Current Zoning: O-15 (CD) (Office, Conditional)
Proposed Zoning: RAC(CD) (Regional Activity Center, Conditional)

Approximately 1.53 acres located north of Carnegie Boulevard, east of Coca-Cola Plaza, and south of Rexford Road.

The petition proposes the development of up to 68,000 square feet of office uses, 6,000 square feet of financial institution uses, and 6,000 square feet of restaurant and retail uses the site is currently occupied by an office building.

Staff recommends approval of this petition upon resolution of outstanding issues related to outstanding issue related to transportation and site and building design.

SHEET NUMBER 11

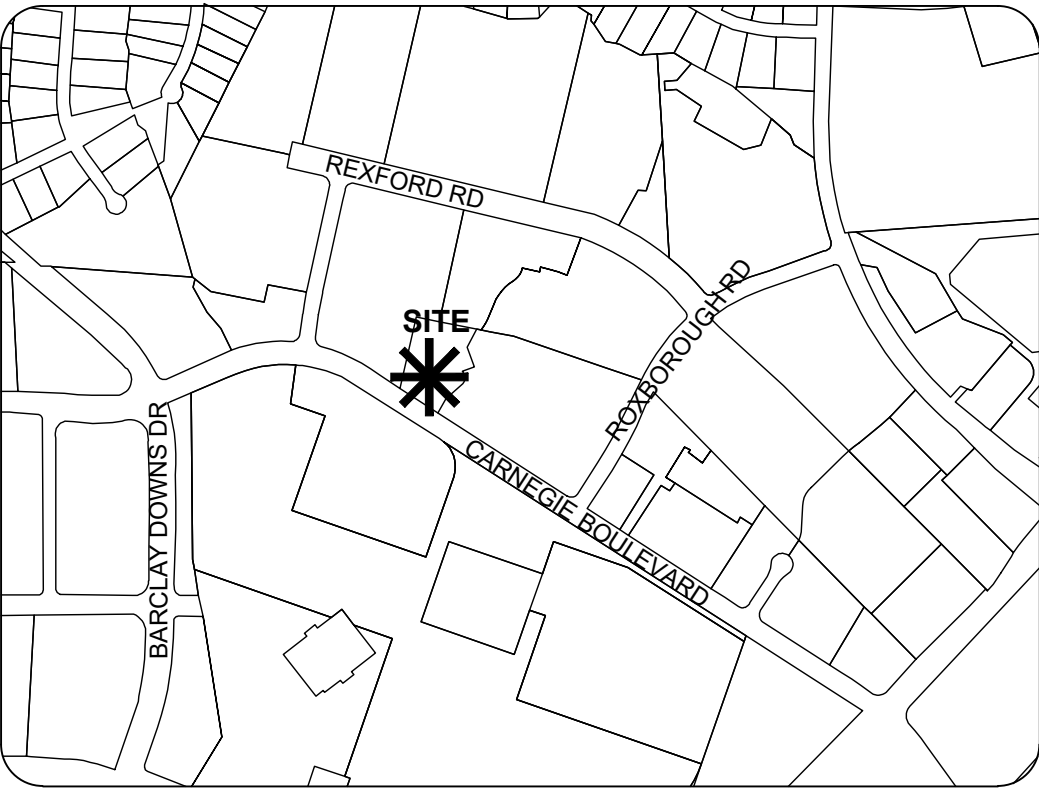
1. Site will trigger Tier 3 multimodal and TDM. Add conditional note that says, "Site will comply with CTR requirements to be finalized in permitting."
2. Revise site plan and conditional note(s) to commit site access off of Carnegie Boulevard to have a minimum separation of 10' from property line, through the right-of-way, per the Charlotte Streets Manual. Revise site plan to show the required spacing for drawn site access. Please be mindful when project goes to permitting that the angle of the driveway entering the public right-of-way must conform with UDO Article 31.
3. Revise site plan and conditional note(s) to commit to construct traffic signal at the intersection of Rexford Drive and Roxborough Road.

4. Open space language: Add language to notes that when each open space element is utilized, the petitioner shall provide the details/technical notes on the element along with the location of the open space element. Add language to paving materials under open space to provide additional information during the land development process. Add language for shading elements to be more prescriptive in the notes. Open space language: Add prescriptive standards for seating. Open space language: Define and add additional detail for public art.
 5. Open space language: remove all references to residential development and/or residential sections of the ordinance.
 6. Dead-end fire apparatus access roads in excess of 150 feet in length shall be provided with an approved area for turning around fire apparatus.
-
